From: Brian Banister [REDACTED]
Sent: 18 February 2026 14:05
To: Planning.Responses <Planning.Responses@arun.gov.uk>
Subject: Arun Conservation Area Advisory Panel comments on applications

Hello,
The **Arun Conservation Area Advisory Panel** wish the following comments to be taken into consideration in the determination of the following applications:

A/10/26/PL - Corner House, The Square, Angmering

Technical detail: 3 - Flat Windows - Supply & Fit - Remove & replace

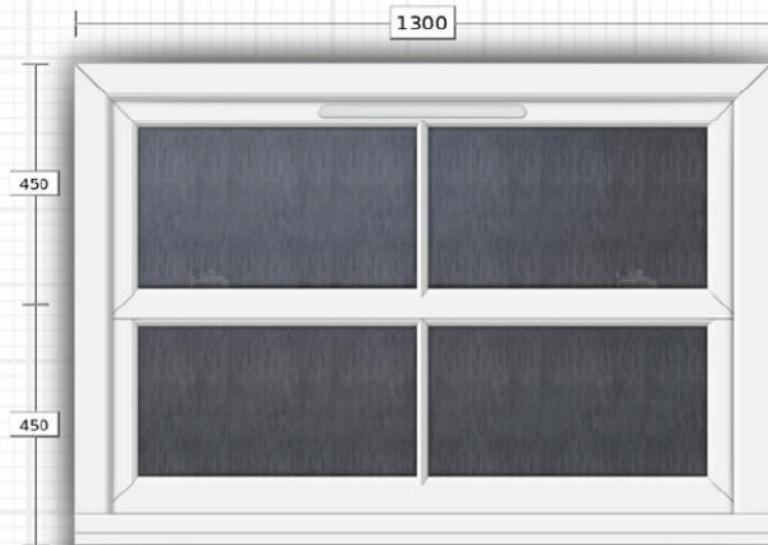
Pvcu windows and doors are generally held not to be suitable in the historic environment due to their lack of subtlety and unconvincing finish, surface reflections, profiles, proportions etc. The loss of traditionally constructed timber fenestration to pvcu replacements invariably leads to a loss of heritage significance in the host building and the wider historic environment. There must be the danger that if approved on this site with its very close physical and visual relationship with other designated and non-designated heritage assets there will be difficulty for the Council in the future to resist similar proposals in the conservation area, very much to the detriment of its heritage significance.

Given the context described, the replacement windows and door need to be of painted timber with slimline double glazing. The windows need to be vertically sliding sashes with properly formed glazing bars. It is suggested that given the proportions of the first floor window openings, a more suitable glazing bar pattern would be 3 panes over 3, and this would better match the fenestration at ground floor level, and improve the appearance of the facade.
